REQUEST

Current Zoning: N1-A (neighborhood) and MUDD-O (mixed-use development district, optional)
Proposed Zoning: MUDD-O (mixed-use development district, optional) and MUDD-O SPA (mixed-use development district, site plan amendment)

SUMMARY OF PETITION

The petition proposes expansion of an existing pet services indoor/outdoor use on current and adjoining site. The expansion will increase the size from 6,000 square feet to up to 8,500 square feet of gross floor area with additional limited outdoor pet services uses.

SHEET TITLE
REZONING PLAN: PETITION # 2023-007

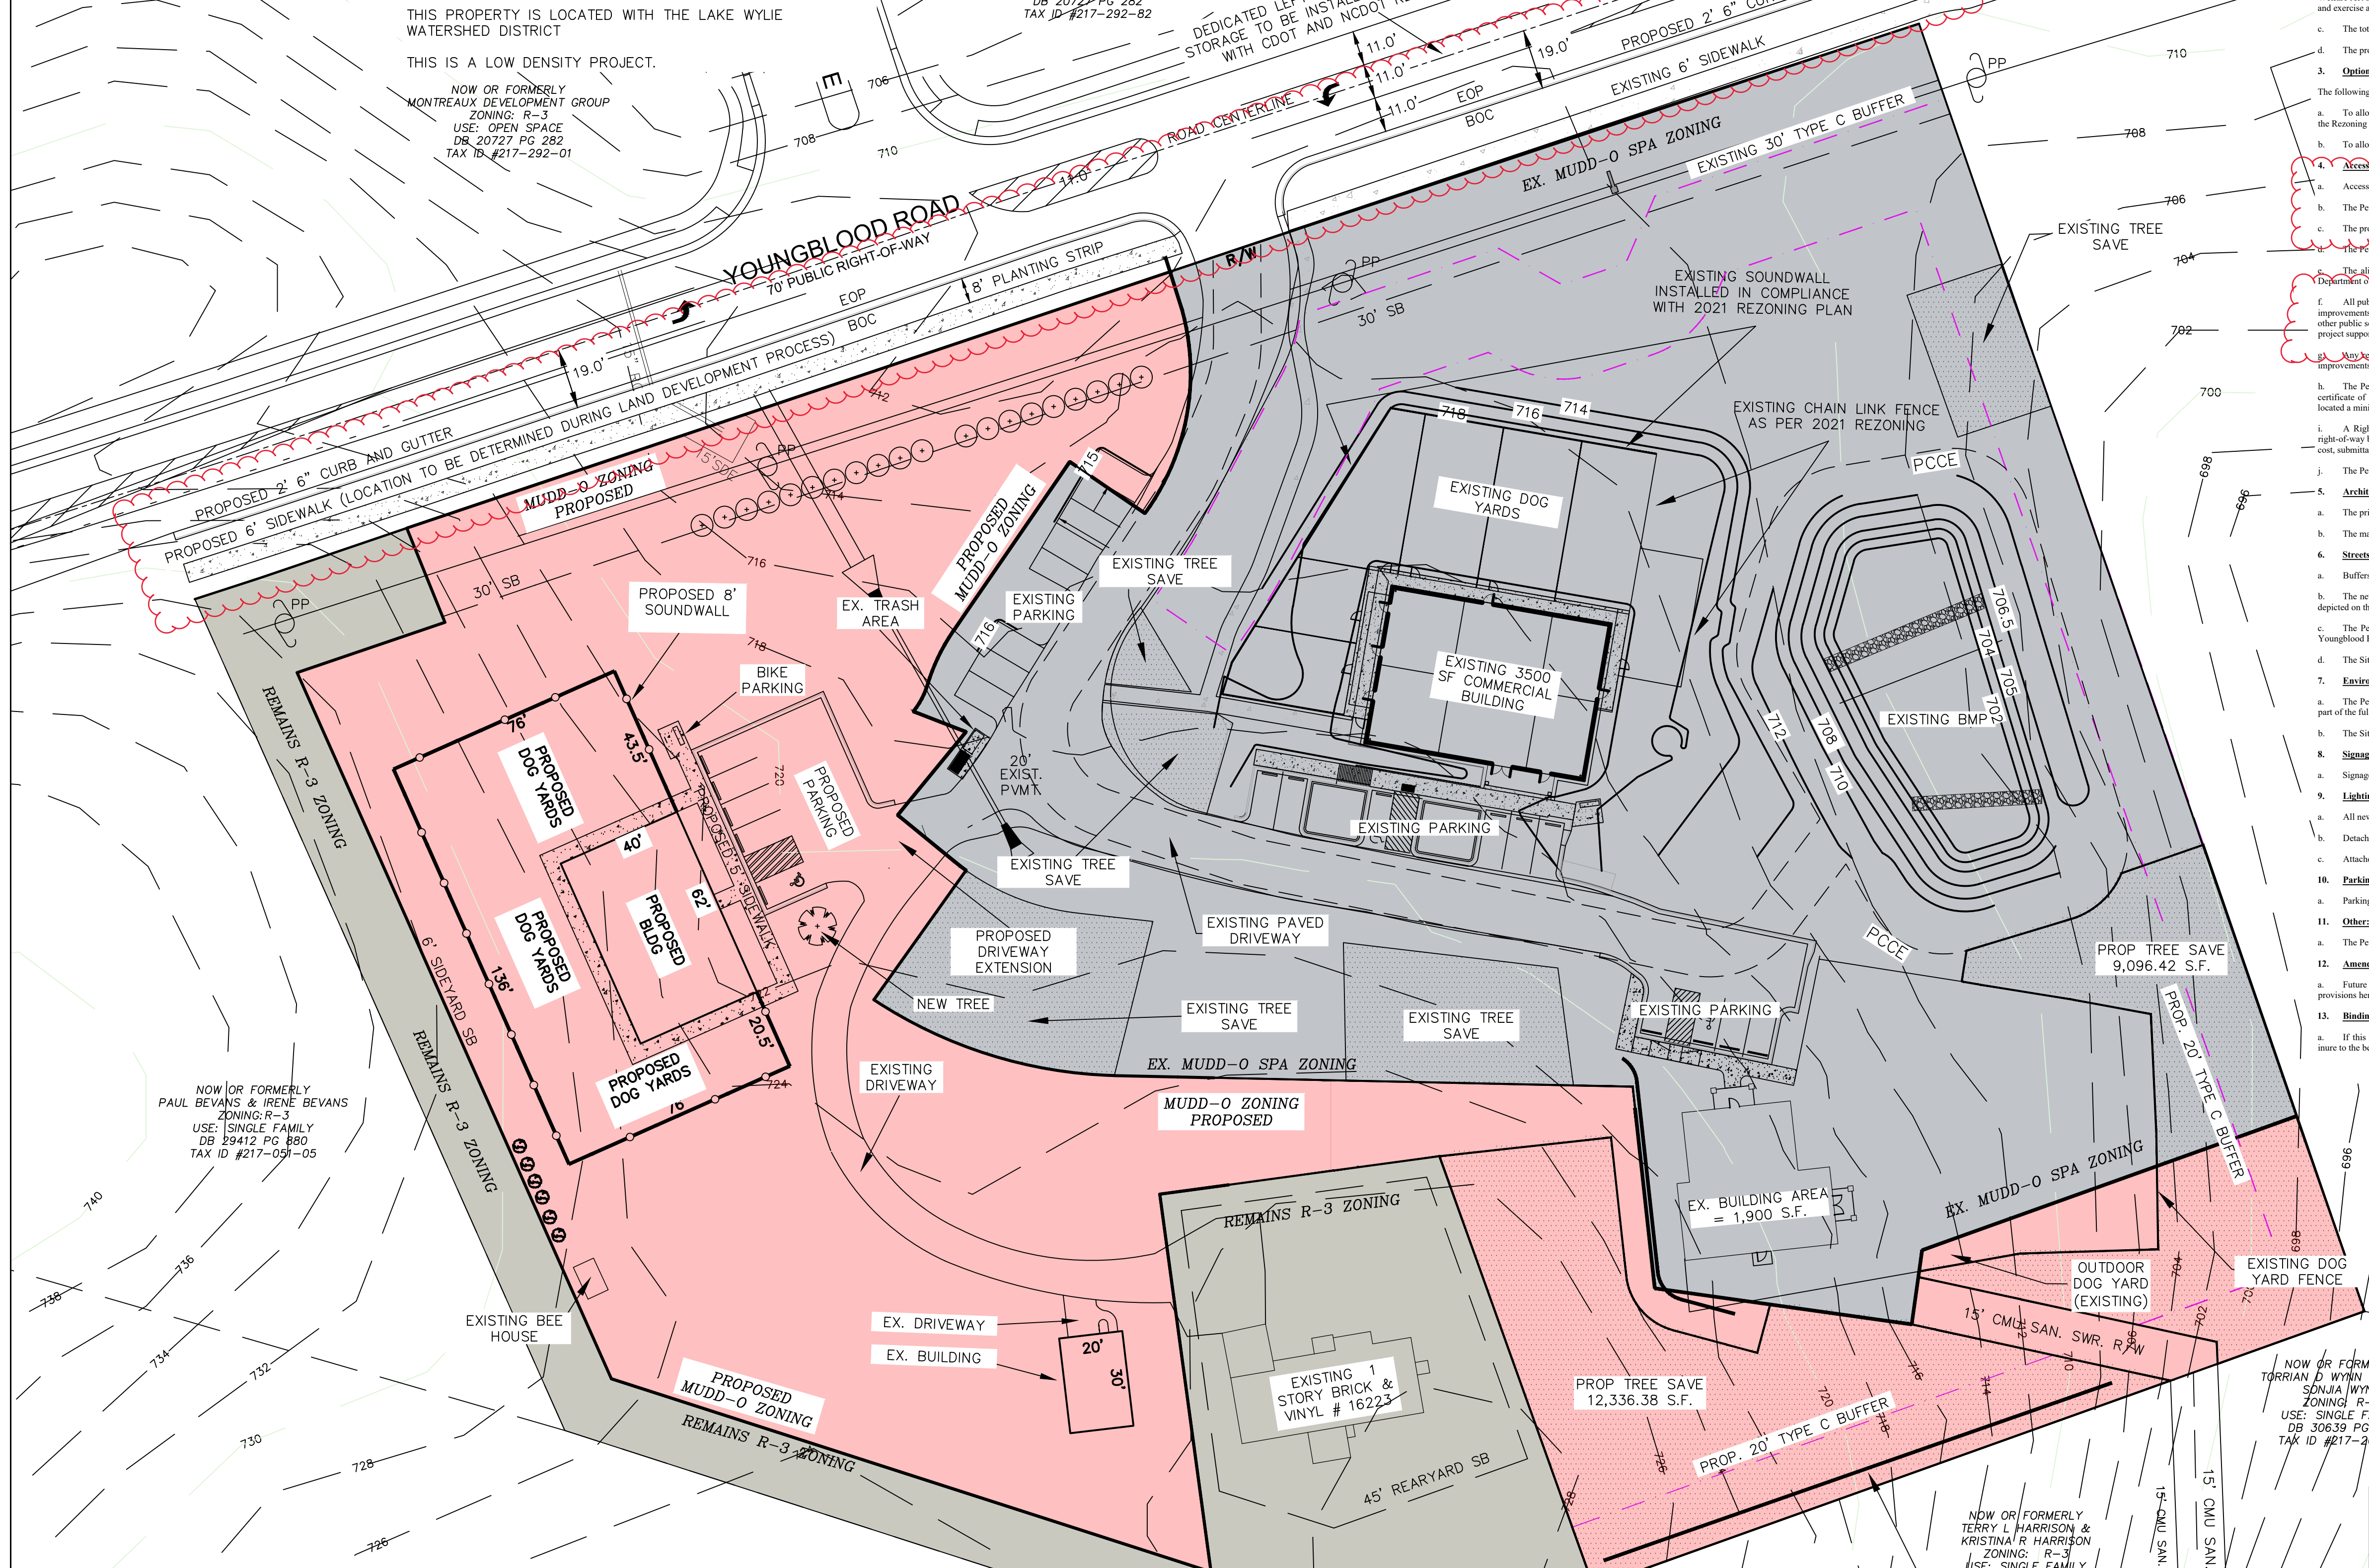
1. Youngblood Road: Location of curb and gutter to be moved to 19 feet from roadway centerline to accommodate the Charlotte Streets Map with a roadway typical section of a 2+ avenue with an 8-foot planting strip and a 12-foot multi-use path. Label and dimension the curb and gutter from the centerline for each road on the site plan.

2. Revise site plan and conditional note(s) to commit to installing a left turn lane on Youngblood Road with 100 feet of storage.
 3. Add conditional note specifying "All public roadway improvements will be subject to the standards and criteria of CDOT and NCDOT, as applicable, to the roadway improvements within their respective road system authority. It is understood that such improvements may be undertaken by the Petitioner on its own or in conjunction with other development or roadway projects taking place within the broad southwestern Mecklenburg area, by way of a private/public partnership effort or other public sector project support."
-
